Maritime &
Coastguard
Agency

Application by RWE Renewables UK Dogger Bank South (West) Ltd and RWE Renewables UK Dogger Bank South (East) Ltd for an Order Granting Development Consent for the Dogger Bank South Offshore Wind Farms, with up to 200 Wind Turbine Generators (WTG), Offshore Substations and Electricity Transmission Infrastructure.

Examination Timetable – Deadline 1 – Written Representation

7.14 Environmental Statement Chapter 14 – Shipping and Navigation (APP-121) and 7.14.14.2 Environmental Statement Appendix 14.2 – Navigation Risk Assessment (APP-124).

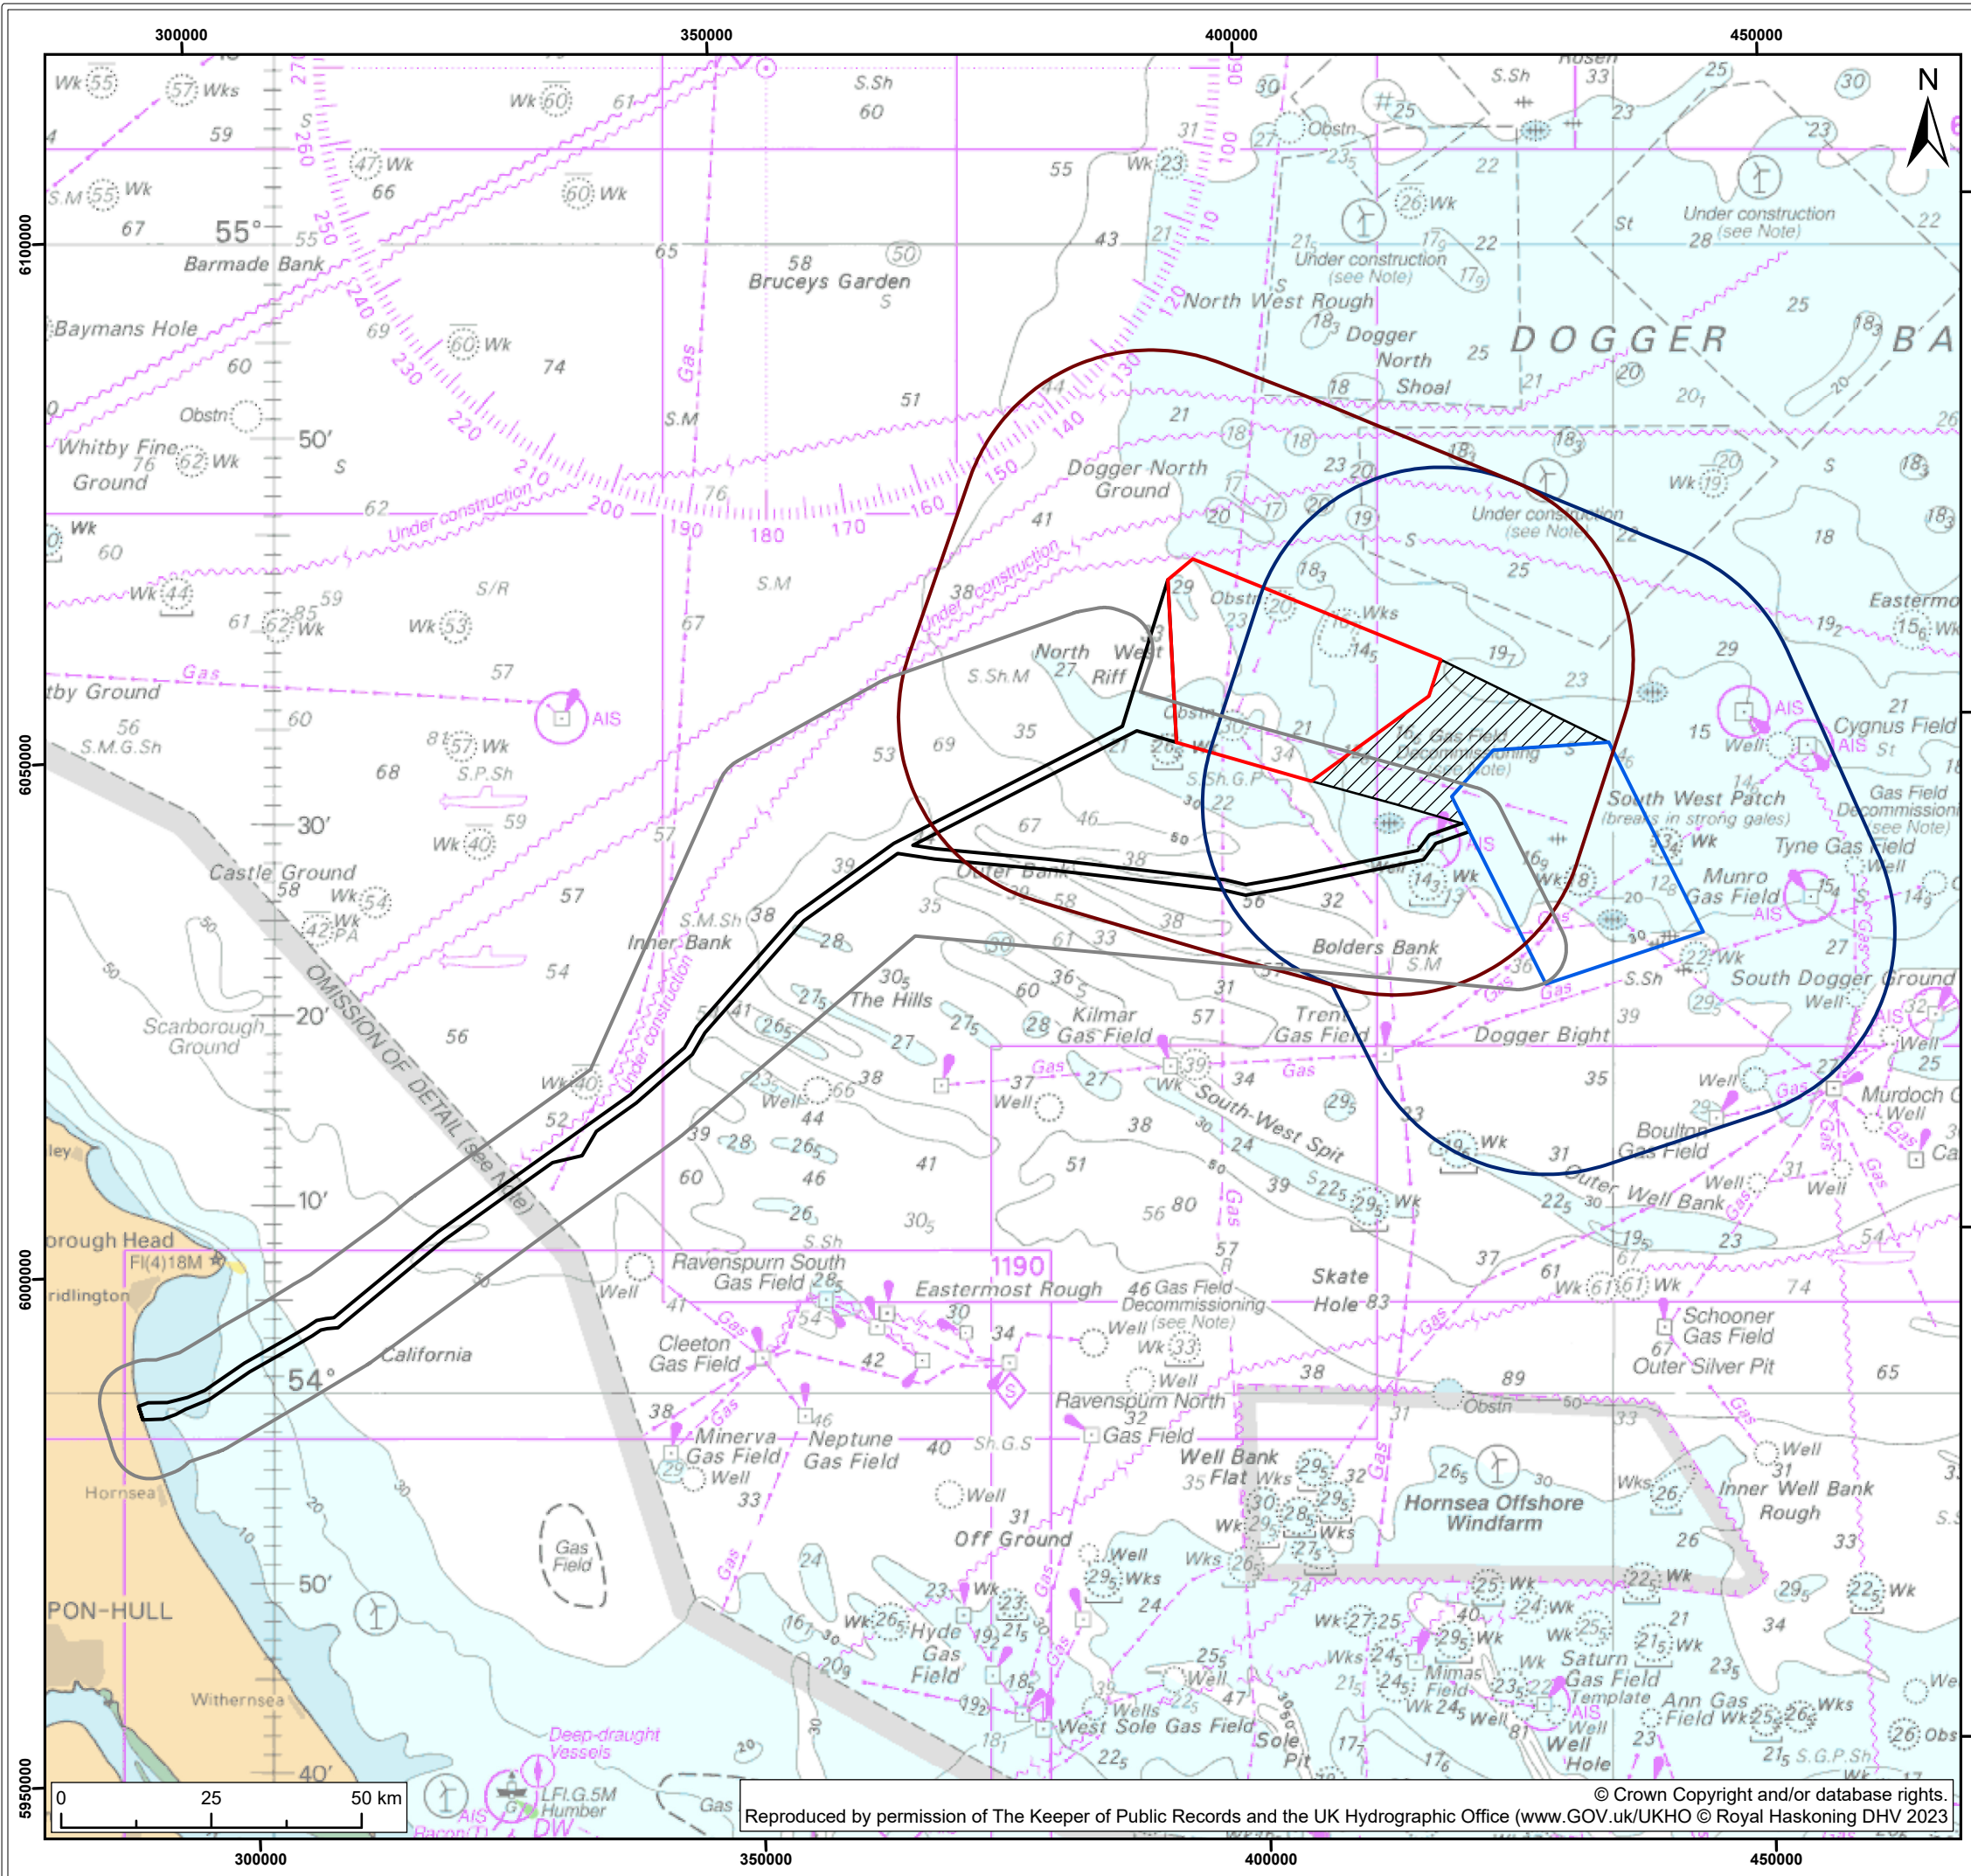
The changes to the Red Line Boundary (RLB) since the initial scoping report have led to an overall increase in the navigable sea room available in the area of proposed development. The current planned boundaries of the East and West arrays as presented in Figure 14-1 of Chapter 14 (APP-122) and Figure 3-2 of the NRA (APP-124), has considered concerns from Stakeholders regarding commercial routing and reduced sea space leading to an increased risk of encounter with other vessels and thus increase in collision risk. Although collision risk has increased as summarised in table 16-1 of the NRA, this increase has been mitigated by the adjustments made by the applicant to the array's respective RLBs. MCA welcomes these changes.
